**WELWYN HATFIELD BOROUGH COUNCIL  
EXECUTIVE DIRECTOR - PLANNING, PUBLIC PROTECTION AND GOVERNANCE**

**DELEGATED APPLICATION**

**Application No:** 6/2022/1110/LAWP  
**Location:** 16 Nimrod Drive Hatfield AL10 9LS  
**Proposal:** Certificate of lawfulness for the creation of rear dormers to existing roof  
**Officer:** Ms Ashley Ransome

DRAWING NO:
 16NDHA 11 A

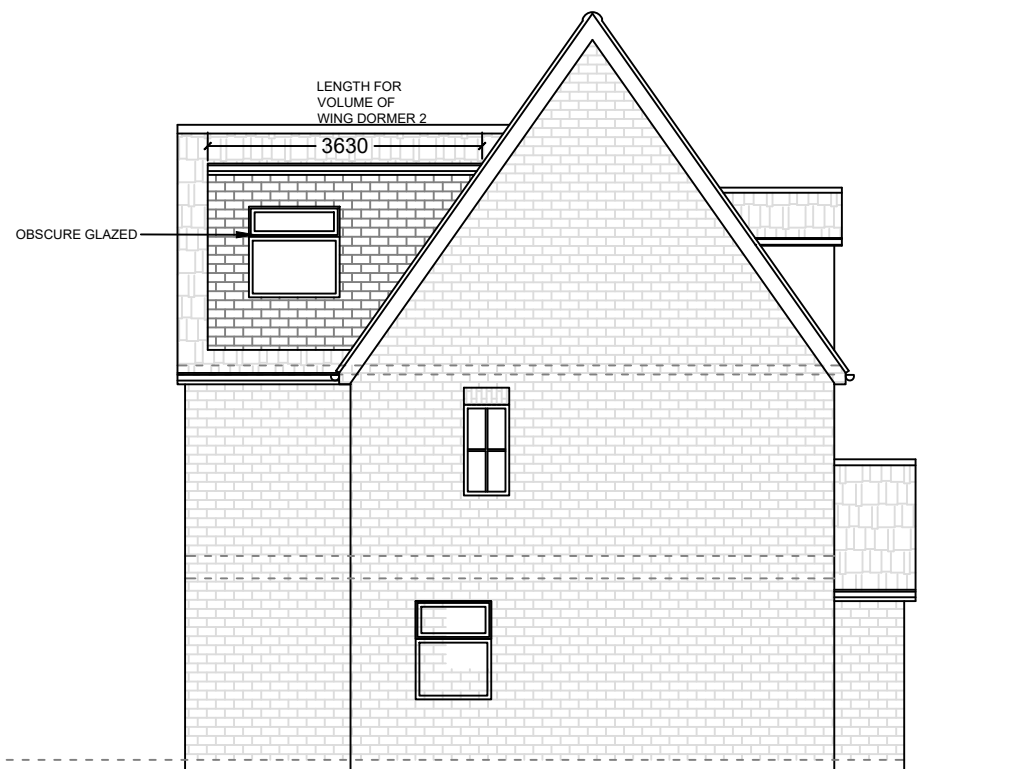
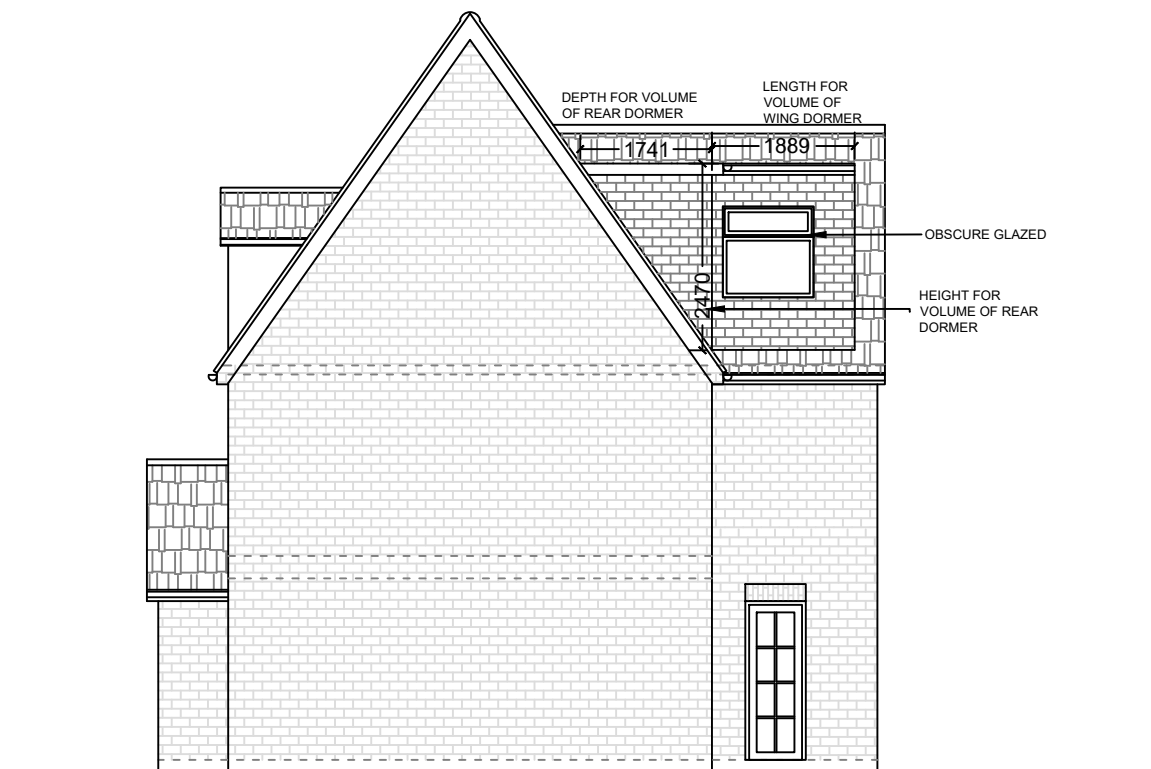
(d) would the cubic content of the resulting roof space exceed the cubic content of the original roof space by more than:- (i) 40 cubic metres in the case of a terrace house, or (ii) 50 cubic metres in any other case	<b>N</b>	N
<i>Calculation in here</i>		
$6.1 \times 2.5 \times 1.7 = 13.0m^3$

2		
$\frac{1.7 \times 2.5 \times 1.9}{2} = 4.1m^3$		
$\frac{1.7 \times 2.5 \times 3.6}{2} = 7.7m^3$		
<b>TOTAL= 24.8m<sup>3</sup></b>		
(e) would it consist of or include:- (i) the construction or provision of a veranda, balcony or raised platform, or (ii) the installation, alteration or replacement of a chimney, flue or soil and vent pipe	<b>N</b>	<b>N</b>
